From: Martyn White <Martyn.White@arun.gov.uk> **On Behalf Of** Conservation Officer
Sent: 14 August 2026 14:05
To: Planning.Responses <Planning.Responses@arun.gov.uk>
Cc: Jonny Cooper <Jonny.Cooper@arun.gov.uk>
Subject: AB/29/26/HH

AB/29/26/HH

Address: White Cottage 32 King Street Arundel BN18 9BW

Proposal: Single storey rear extension to create an orangery.

Drawing Number
07 - PROPOSED
SIDE ELEVATIONS

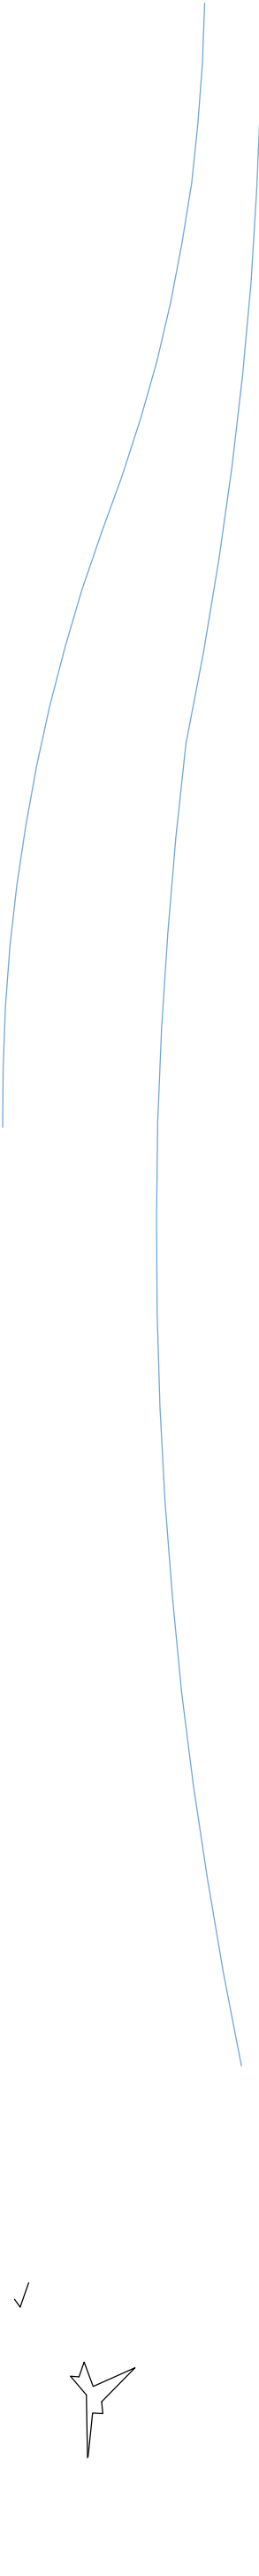
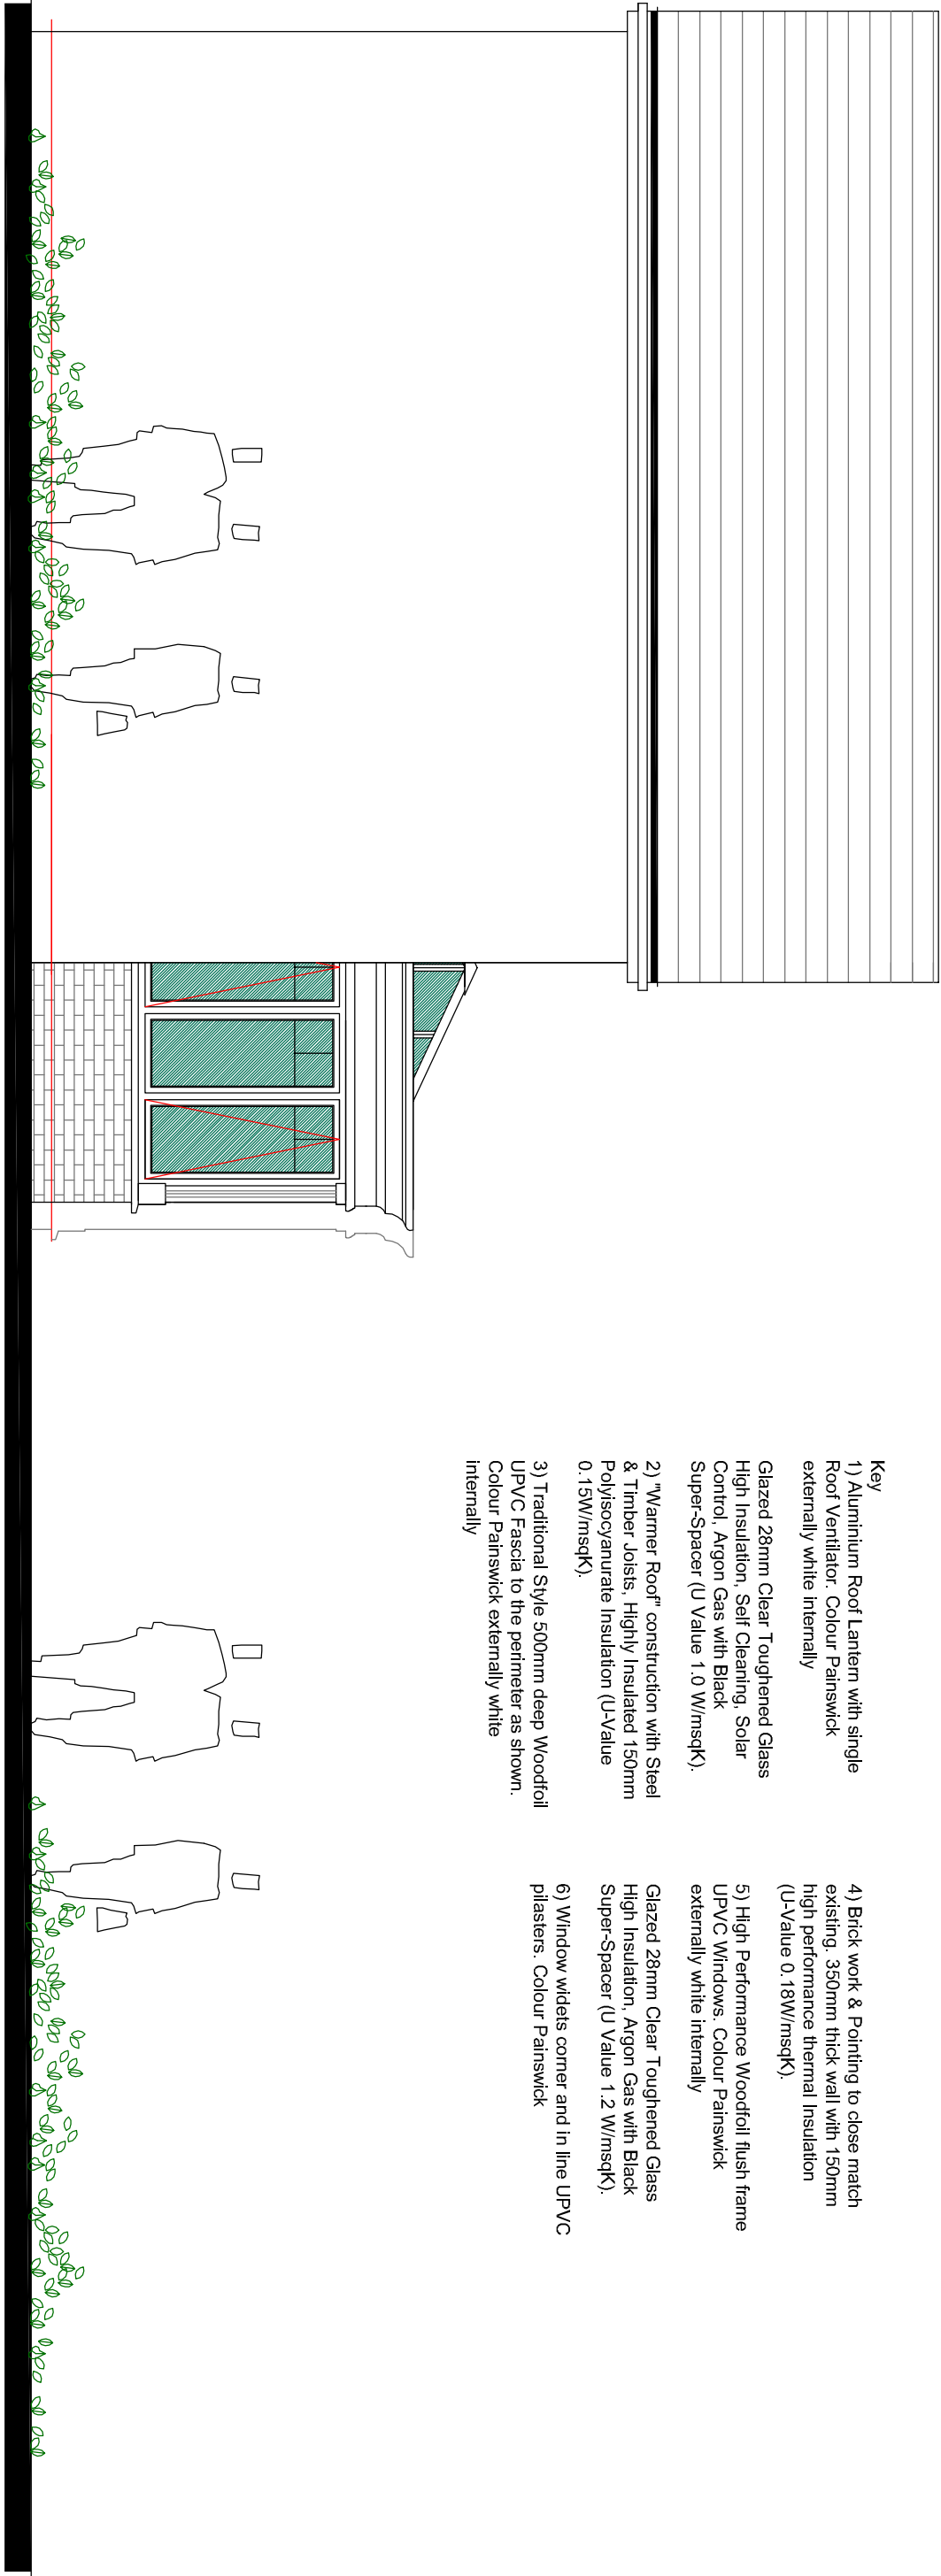
Whilst the use of uPVC would not normally be supported on heritage grounds, uPVC windows are already present throughout the building. Given that the extension is located to the rear of a non-listed property, and that the proposed windows would match those already within the building, there is insufficient justification to require timber windows in this instance. Consequently, no heritage objection is raised to the proposal.
